Please find attached GREAT's submission of traffic for Deadline 5.

## **GREAT Comments about Traffic at Issue Specific Hearing 6 on 11 September 2019 on Environmental Matters**

Figure 2.2 – Construction Vehicle Profile

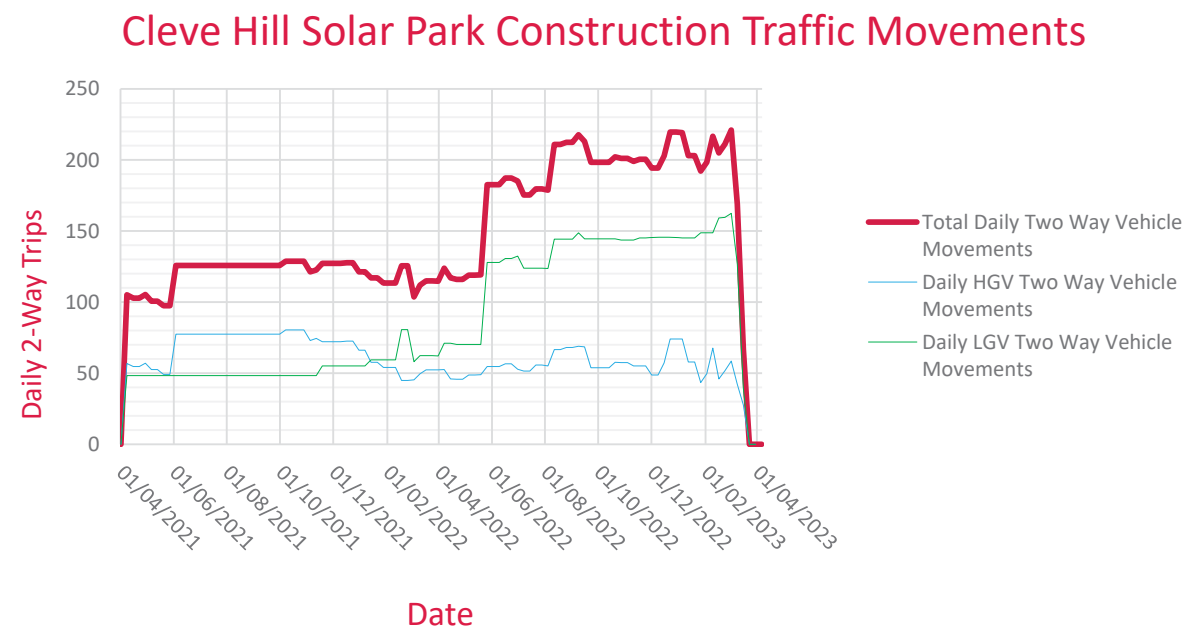
- Looking at the figures stated in the Outline Construction Traffic Plan (Revision C, August 2019) for the Cleve Hill development (challenged and not yet validated):

- The average HGV level will be 31 lorries per day (62 movements) throughout the 24 month construction period.
  - Peak daily total construction traffic is expected to occur in week 100 (challenged and not yet validated as the documentation shows this continues for the rest of the construction period) of the construction programme. This comprises of 81 HGV's (162 movements).
